**Consultation Response from KC,  
Lead Local Flood Authority**

**2024/92806 Land at, Penistone Road, Fenay Bridge, Huddersfield, HD8 0AW**

**Discharge of details reserved by conditions 20 (surface water discharge), 21 (flood routeing) and 31 (grass-crete and batter maintenance) of previous permission 2022/93154 for erection of 68 dwellings with associated access, parking, open space, landscaping and infrastructure works (including installation of surface water attenuation tank)**

**Date Responded: 7<sup>th</sup> February 2025**

TITLE
DETAILS OF ATTENUATION/STORAGE
TANK DETAILS USING POLYSTORM
PSM1A UNIT.

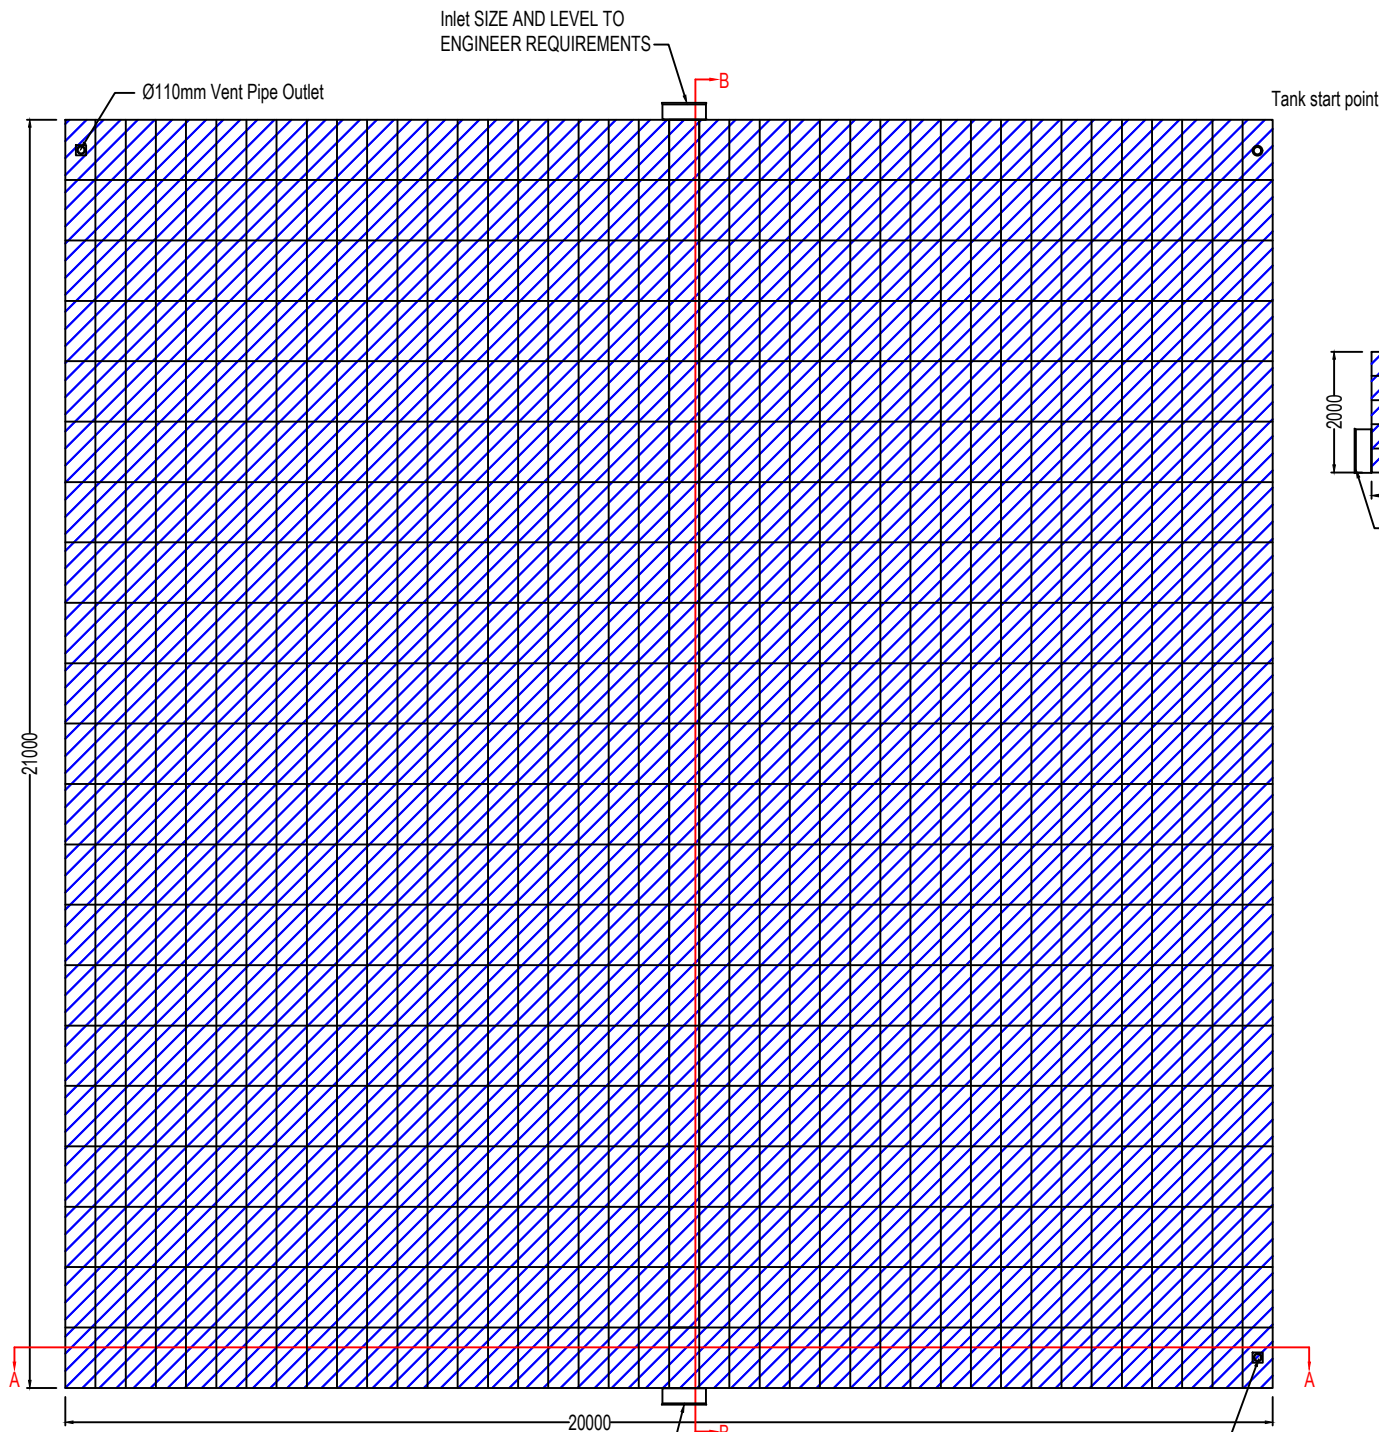
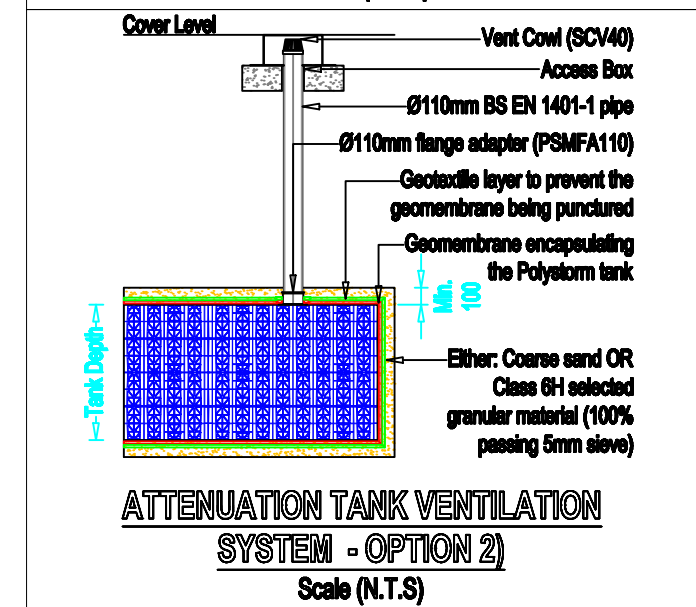
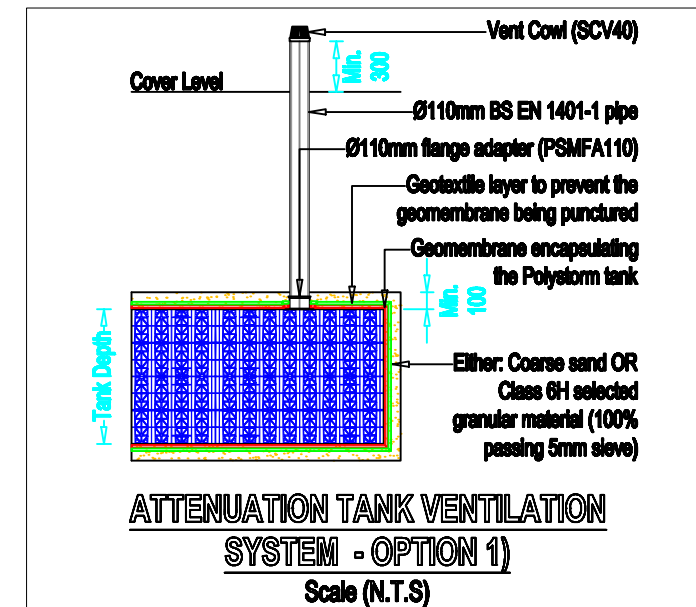
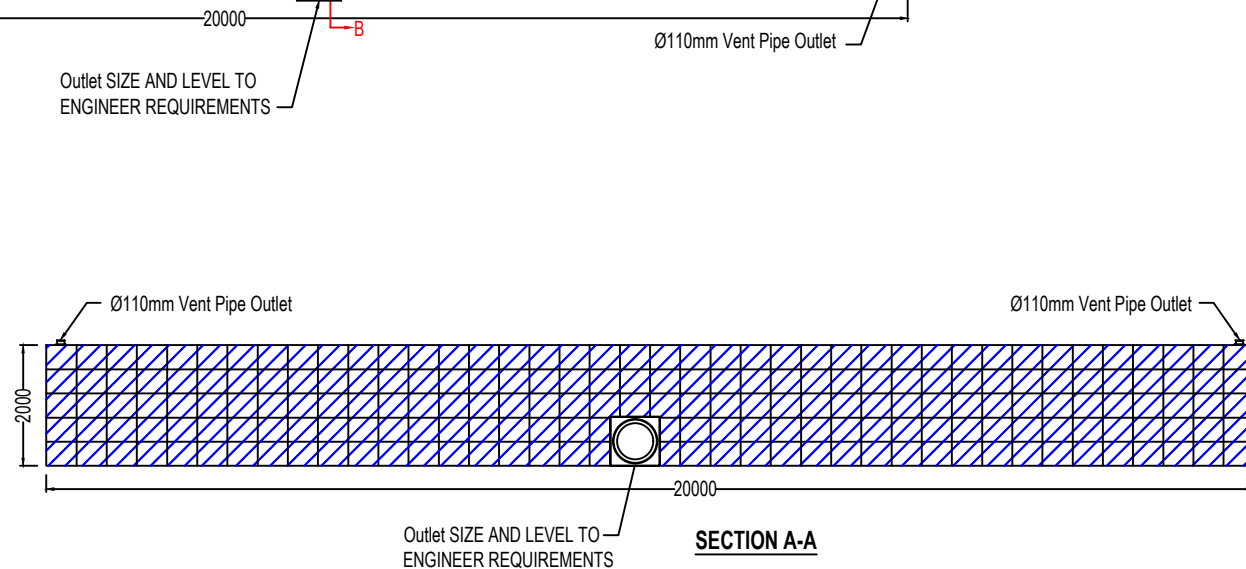
It is apparent that crate storage, Polyform R, is used on this site. Details of a Carlow tank are still present in submitted documents and should be removed.

Details should be supplied from the manufacturer as to loading restrictions in a field with only 600mm of cover to the soffit of the crate. Weight of vehicles are likely to be that of a grass cutter and potential agricultural vehicles.

SECTION A-A
THROUGH ATTENUATION TANK

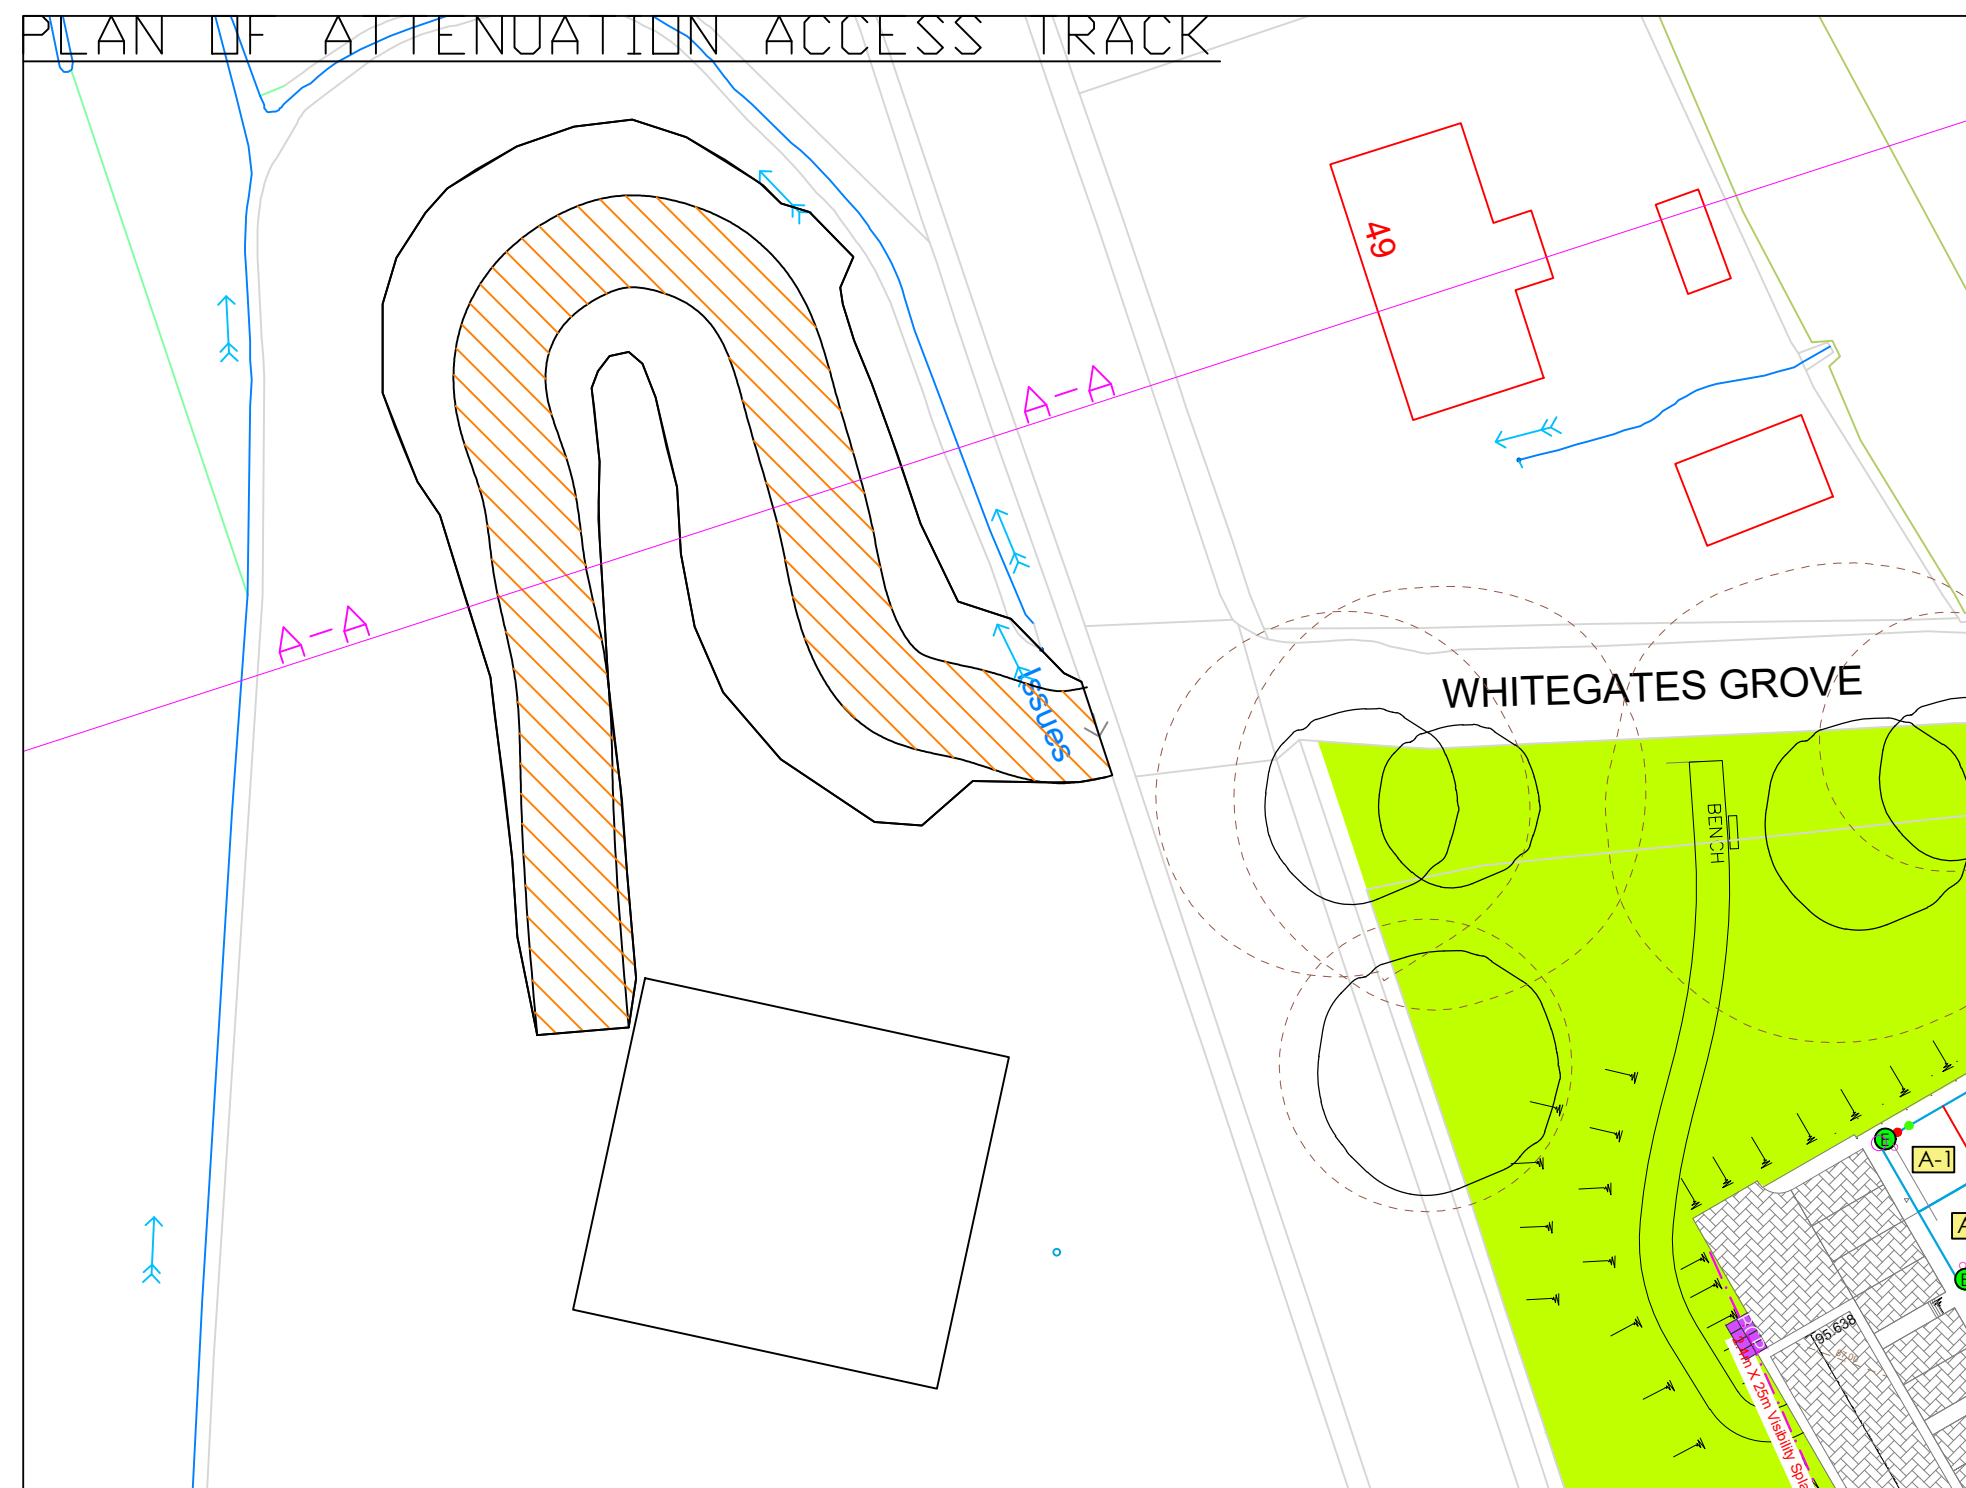
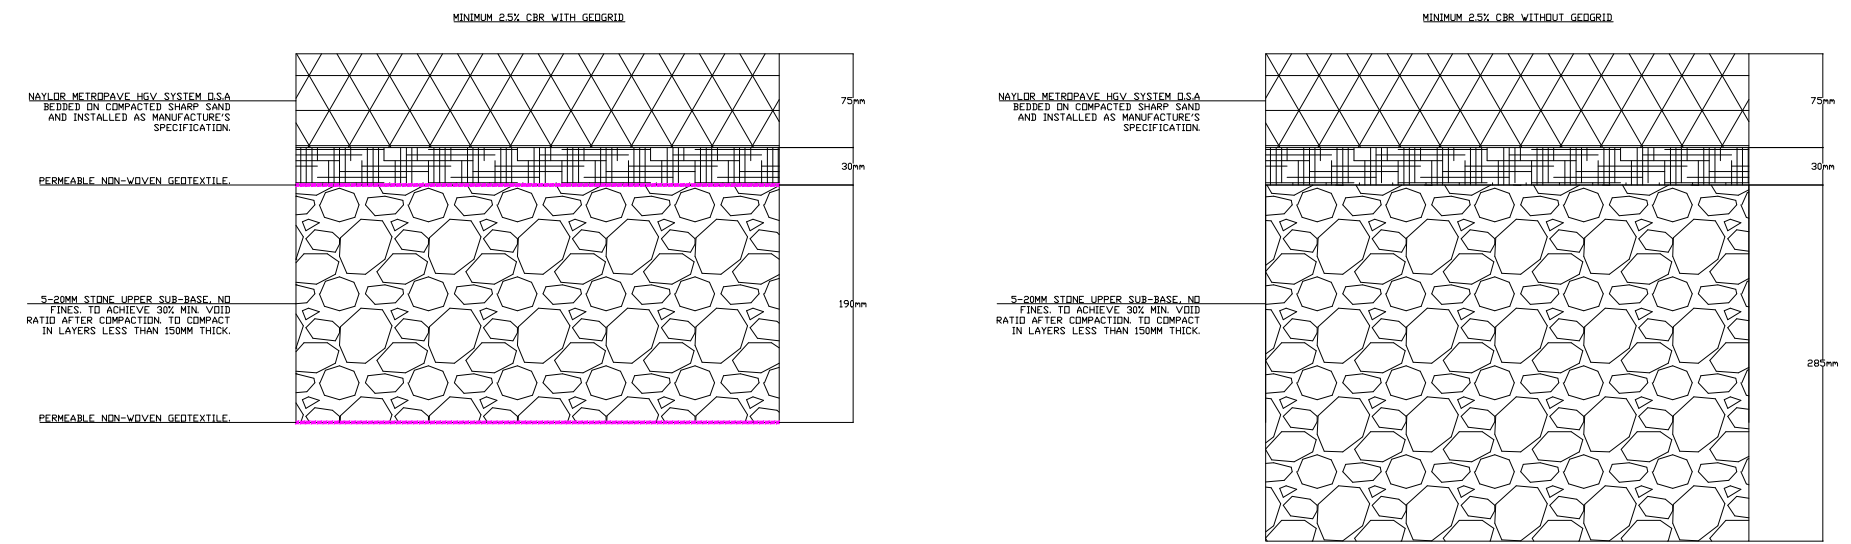
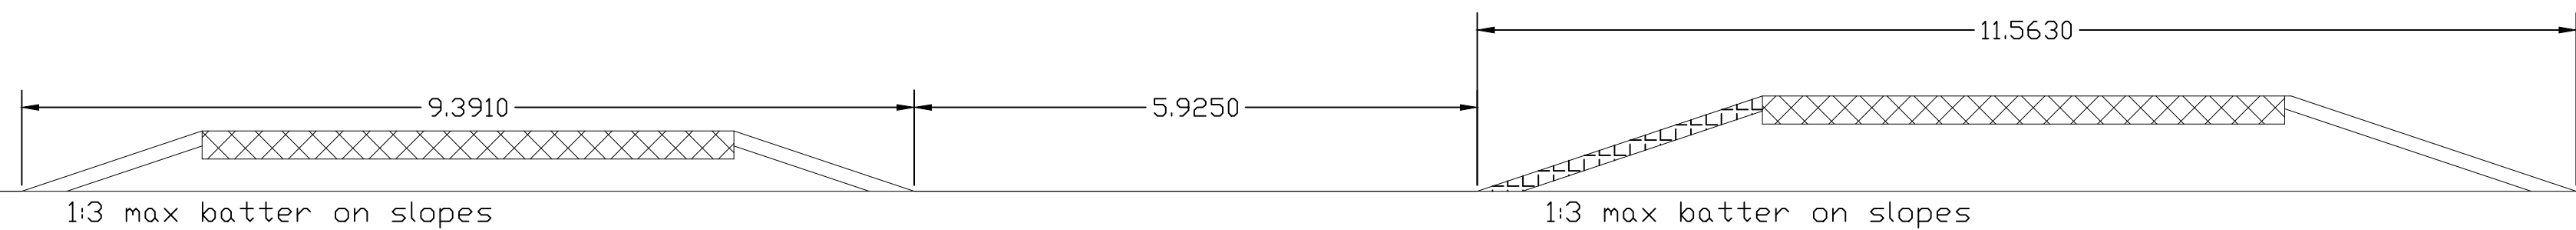
Longitudinal sections show a 600mm pipe entering at soffit level and a 600mm pipe exiting at invert level. It is not clear therefore how this tank can be adequately cleaned as part of an acceptable maintenance plan. A technical approval letter from Yorkshire Water or a NAV equivalent is required therefore under section 104 of the Water Industry Act 1991, to demonstrate that a statutory undertaker would be happy to adopt this design.
